8 May 2013
Our Ref: 7907A.9ER

Re: MP09_0146 for the Redevelopment of Eastlakes Town Centre

This letter addresses the issues raised by the NSW Department of Planning and Infrastructure (DoPI/The Department) in an email dated 11 April 2013 and the matters raised by McLaren Traffic Engineering and Atkins Acoustics, specialist consultants engaged by Botany Bay Council, in their responses to Council dated 9 April 2013 and 3 April 2013 respectively. This letter also considers the matters discussed at a meeting at Botany Bay Council on 24 April 2013.

KEY PLAN 1:500 @ A3.

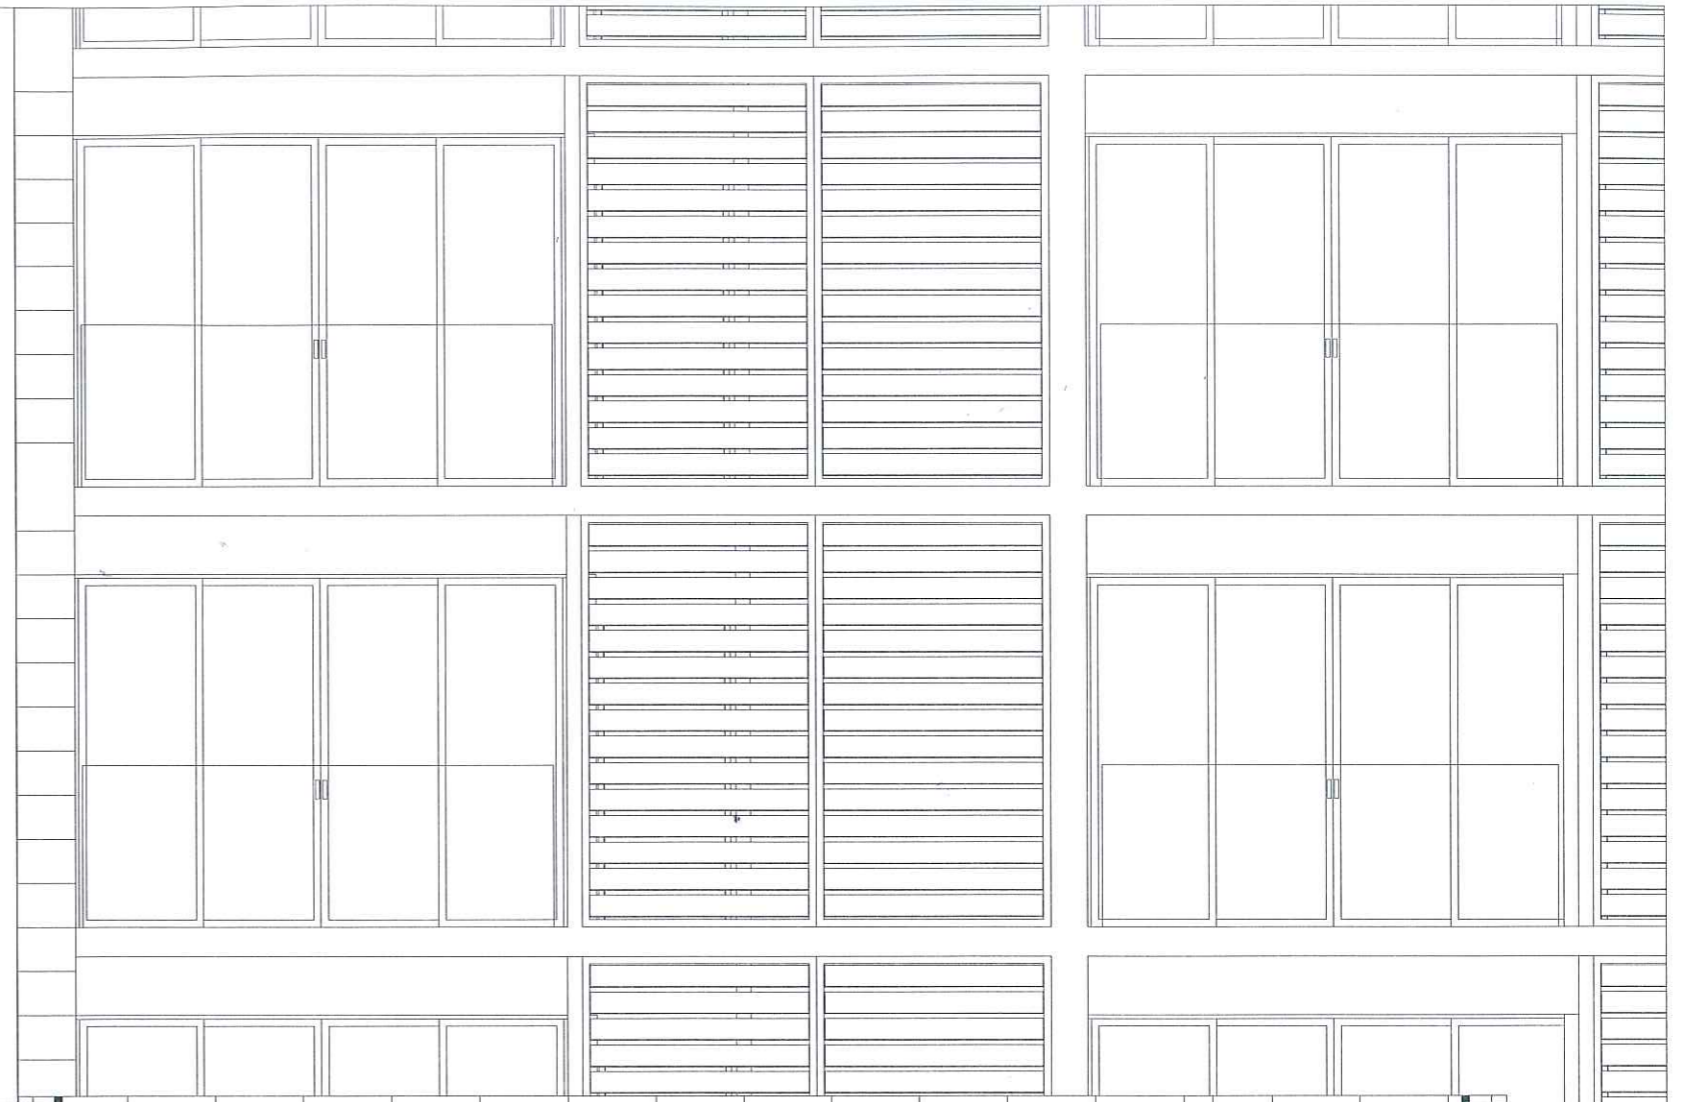
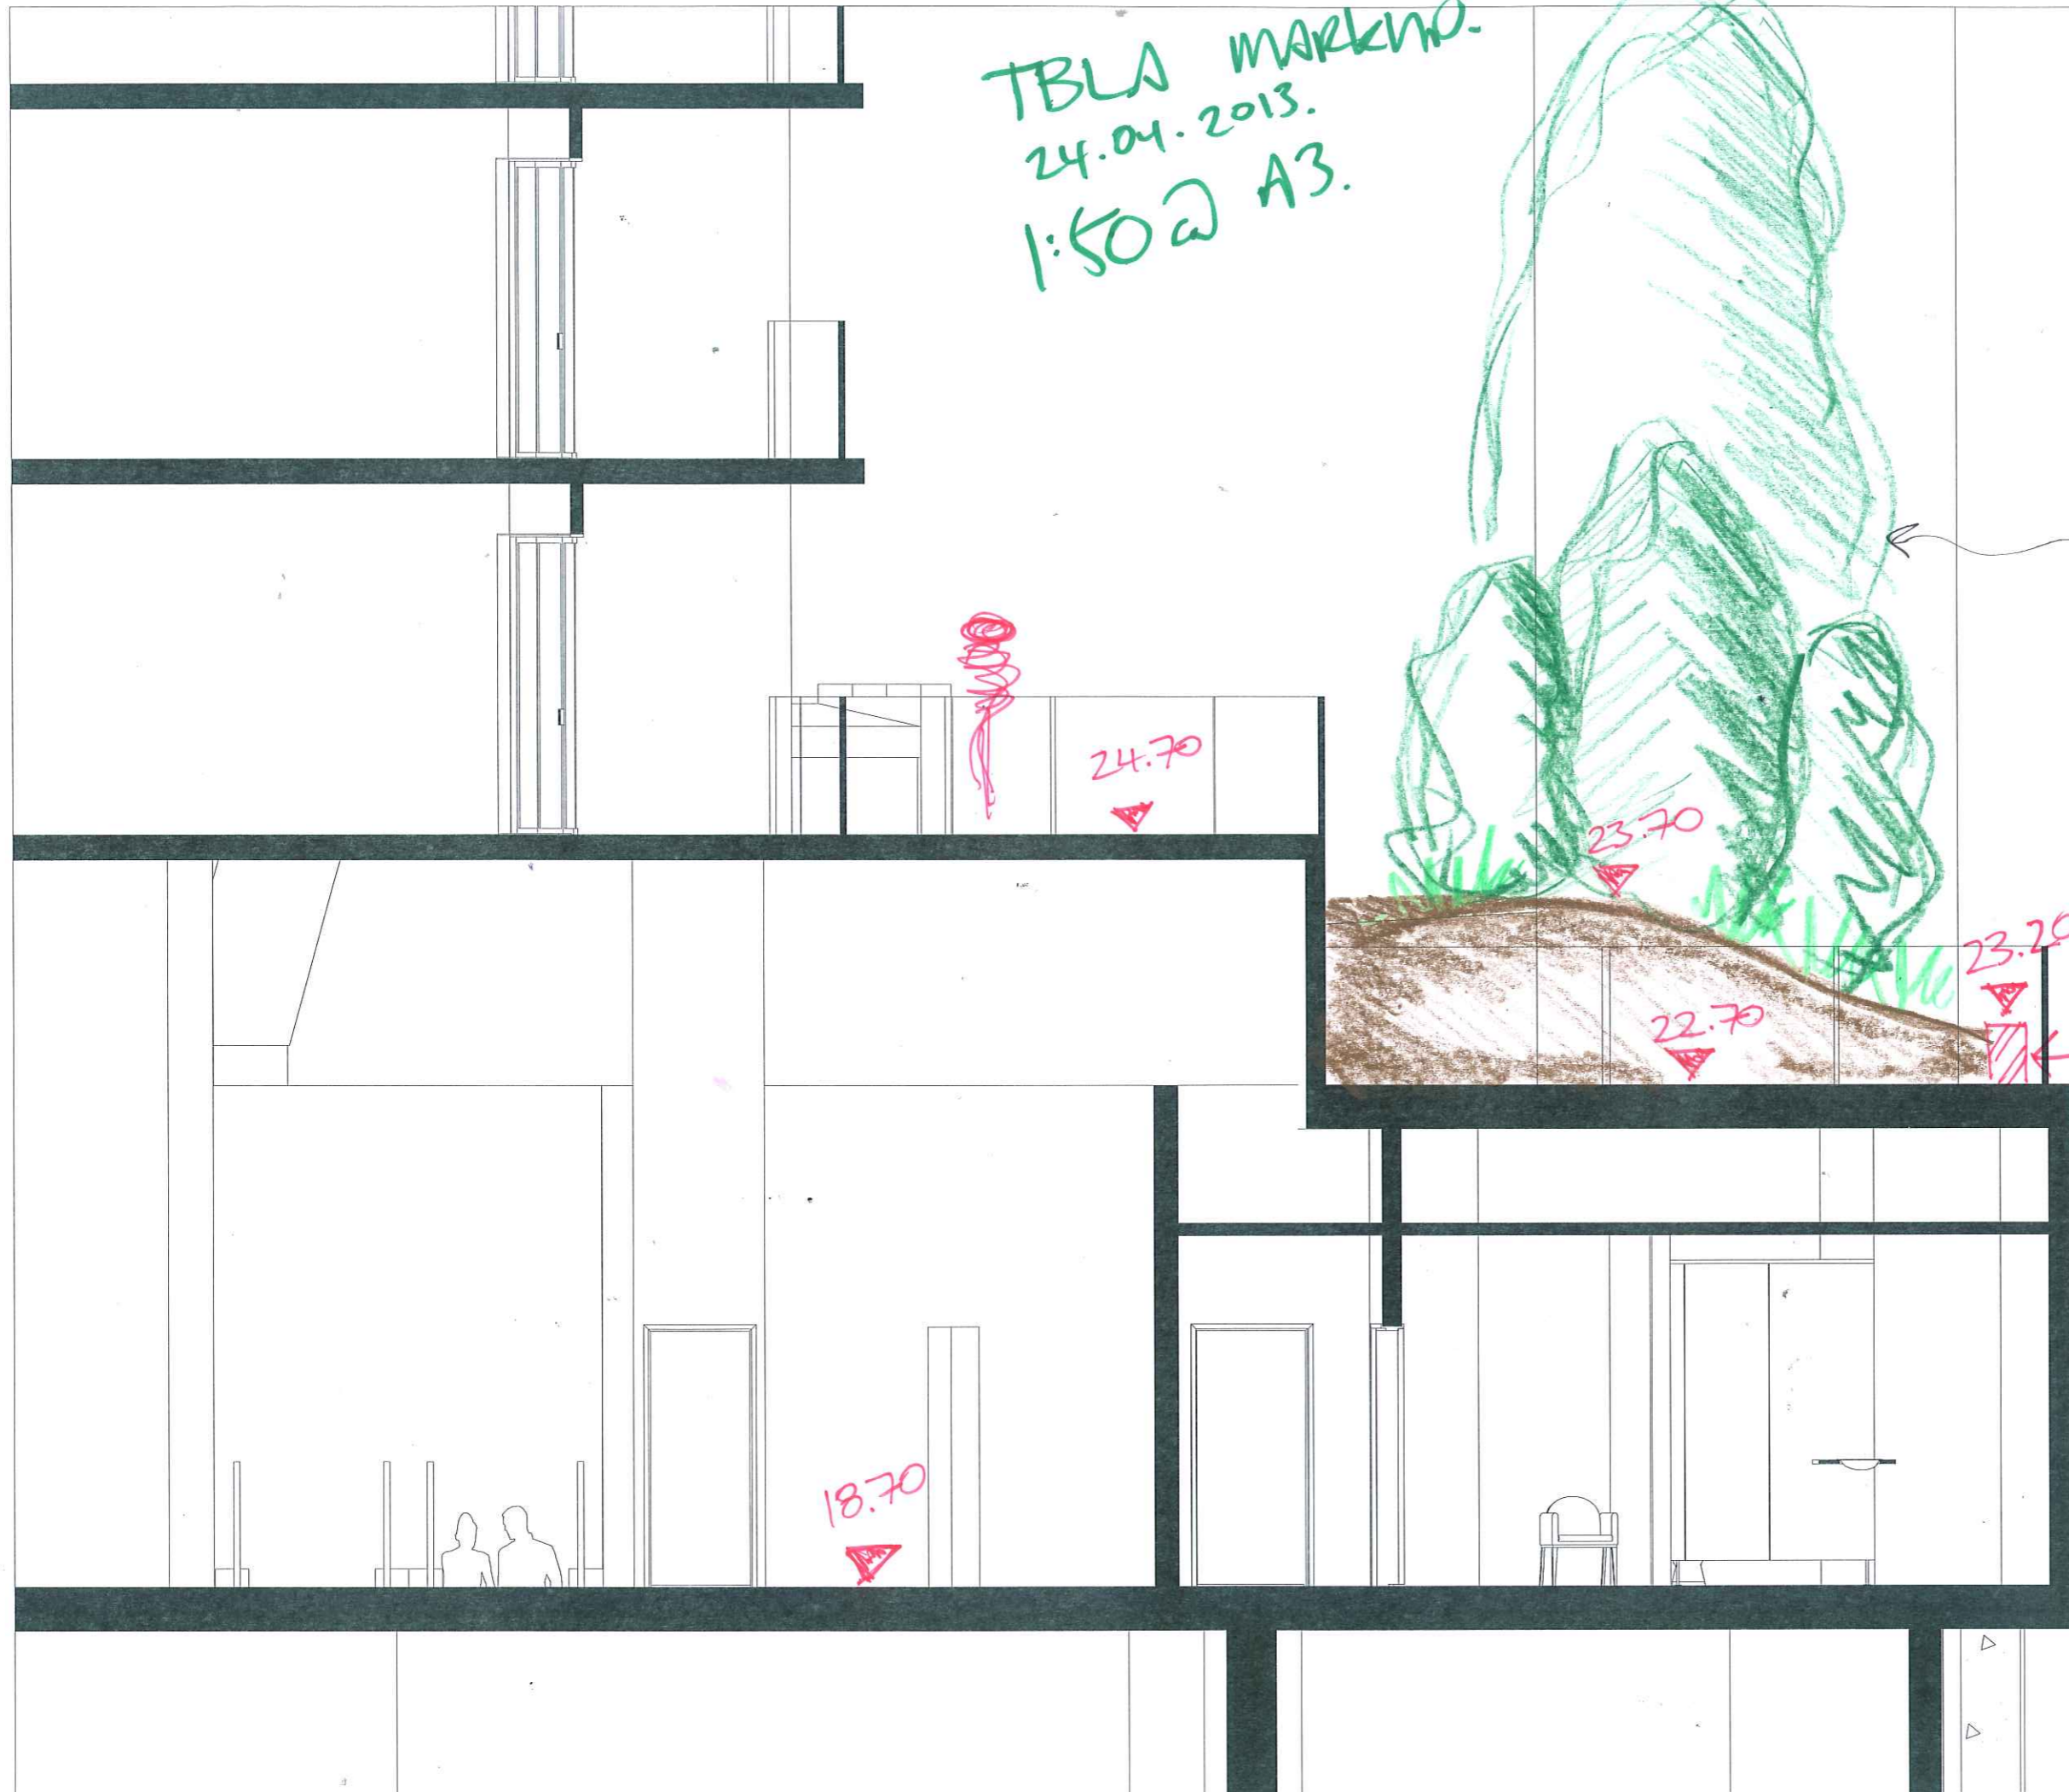
Detailed cross sections with RLs are required showing how a soil depth of 1 metre to support proposed trees can be achieved on the eastern and western edges of the northern podium without increasing podium wall height.

Attachment C to this letter is a sketch plan (in section) of the western and eastern sides of the podium on the northern site. The sketches indicate that soil depths of up to 1m can be accommodated on the western side of the podium without any modification to the podium wall height. On the eastern side, a soil depth of 1m can be provided with the provision of a block wall of 500mm in height inside the balustrade to be provided along the top of the podium wall. Therefore, heights of the podium walls will not need to be increased in order to provide soil depths of 1m for the landscaping along the top of the podium.
